Appeal Decision

Appeal Ref: 6002992

42 Painter Wood, Whalley Old Road, Billington, Lancashire BB7 9JD

- The appeal is made by Mr. & Mrs. Simon Howarth against the decision of Ribble Valley Borough Council.
 - The application Ref. is 3/2025/0818.
 - The application sought planning permission for "Single storey extensions to side and rear. Alterations to fenestration." without complying with a condition attached to planning permission Ref. 3/2020/0163, dated 29 April 2020.

EXISTING AND PROPOSED
ELEVATIONS FRONT

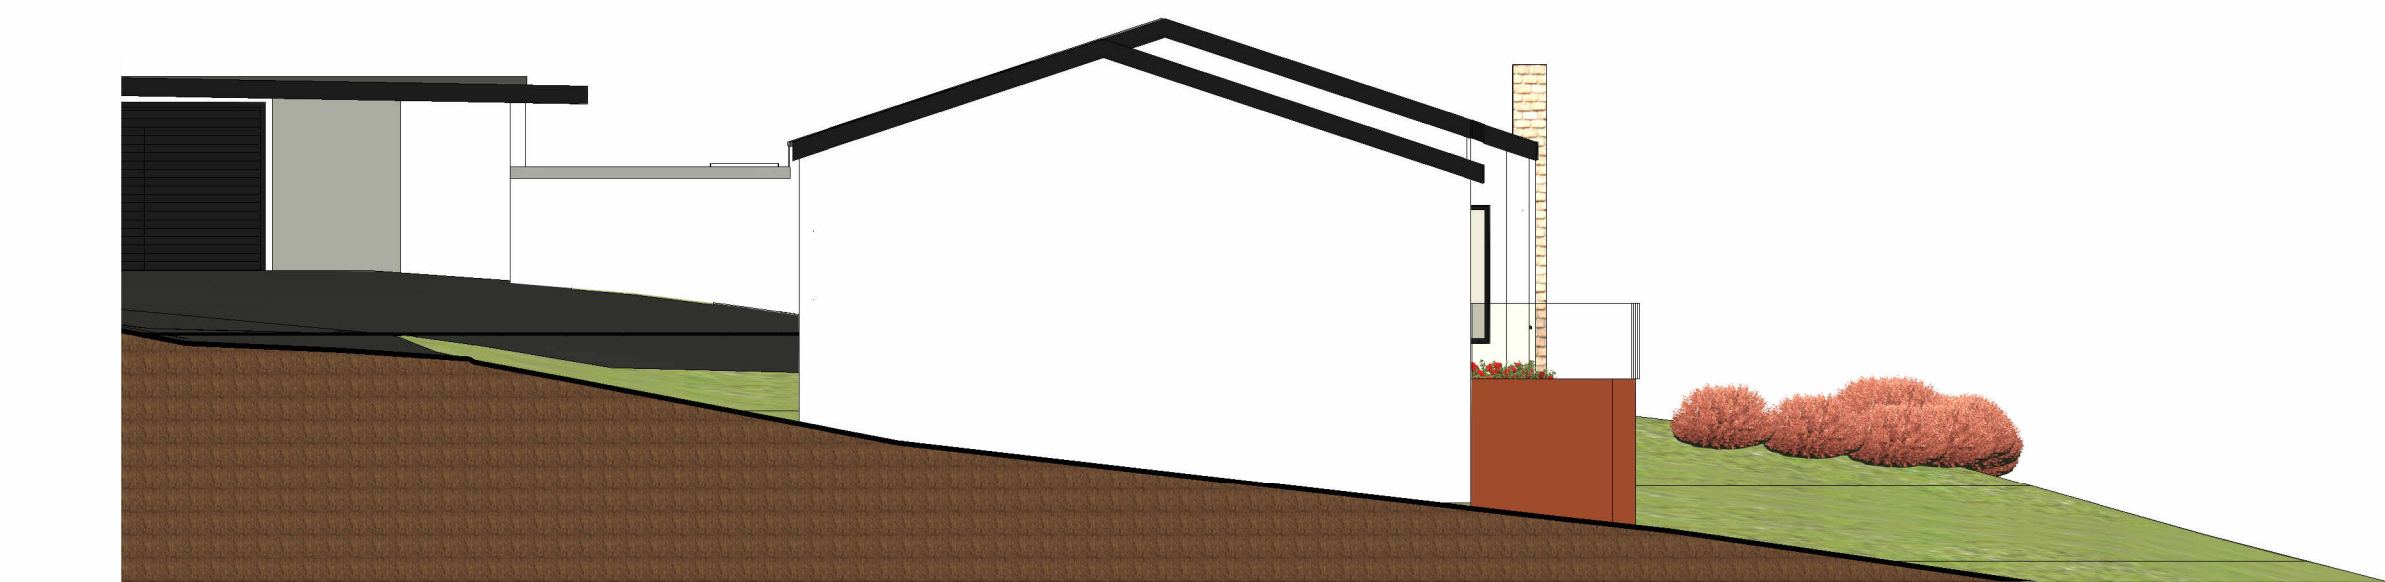
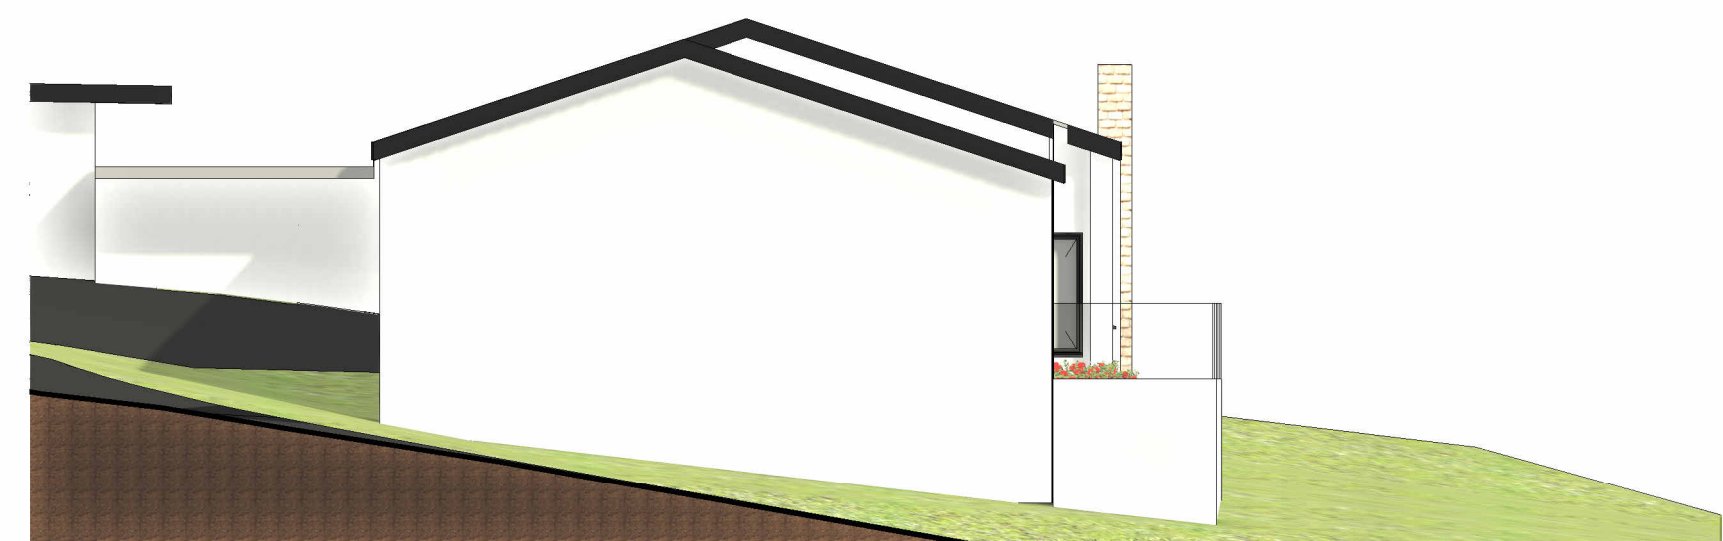
3. Planning permission was granted in 2020 for single storey extensions to the side and rear and alterations to the fenestration, subject to conditions including condition No. 2, which specifies the approved plans. The appeal proposal seeks to vary this to substitute a plan to replace the white render finish of the front balcony wall with Corten steel cladding. The main issue is the effect that varying the condition, and the addition of the cladding as opposed to white render, would have on the character and appearance of the host dwelling and surrounding area.

4. The appeal property is a detached bungalow positioned on elevated land. Its front elevation incorporates a mix of render, timber cladding and stone and it sits within a row of detached dwellings which also feature a mixed material palette.

5. Whilst the proposed finish would introduce a new material and colour to the front elevation, it would integrate well with the mix of existing materials already featured on the host dwelling. Properties along Whalley Old Road also display a similarly diverse range of materials that include red hanging tiles, red brick, a red steel door and zinc cladding. In this context, the proposed Corten steel cladding would sit comfortably within this existing variety, reflecting both the use of metal elements and the red toned finishes along the road. Given its placement to a small area within the broad front elevation, it would also appear as a modest and inconspicuous feature, even when accounting for the property's elevated siting.

6. As no harm is found on the main issue, the lack of an amendment for an alternative material is not determinative. The proposal would not cause harm to the character and appearance of the host dwelling or the surrounding area. As such, it would not conflict with Policy DMG1 of the Core Strategy 2008 - 2028 or Paragraph 140 of the National Planning Policy Framework. These seek for, amongst other things, a high standard of building design and to ensure that the quality of approved development is not materially diminished between permission and completion.

- 1) The development hereby permitted shall be carried out in accordance with drawing nos: Location Plan Scale 1:1250; Existing and Proposed Elevations Front A300; Proposed Section Plan A204; Proposed Garage Floor Plan A207; Proposed Floor Plan A202.
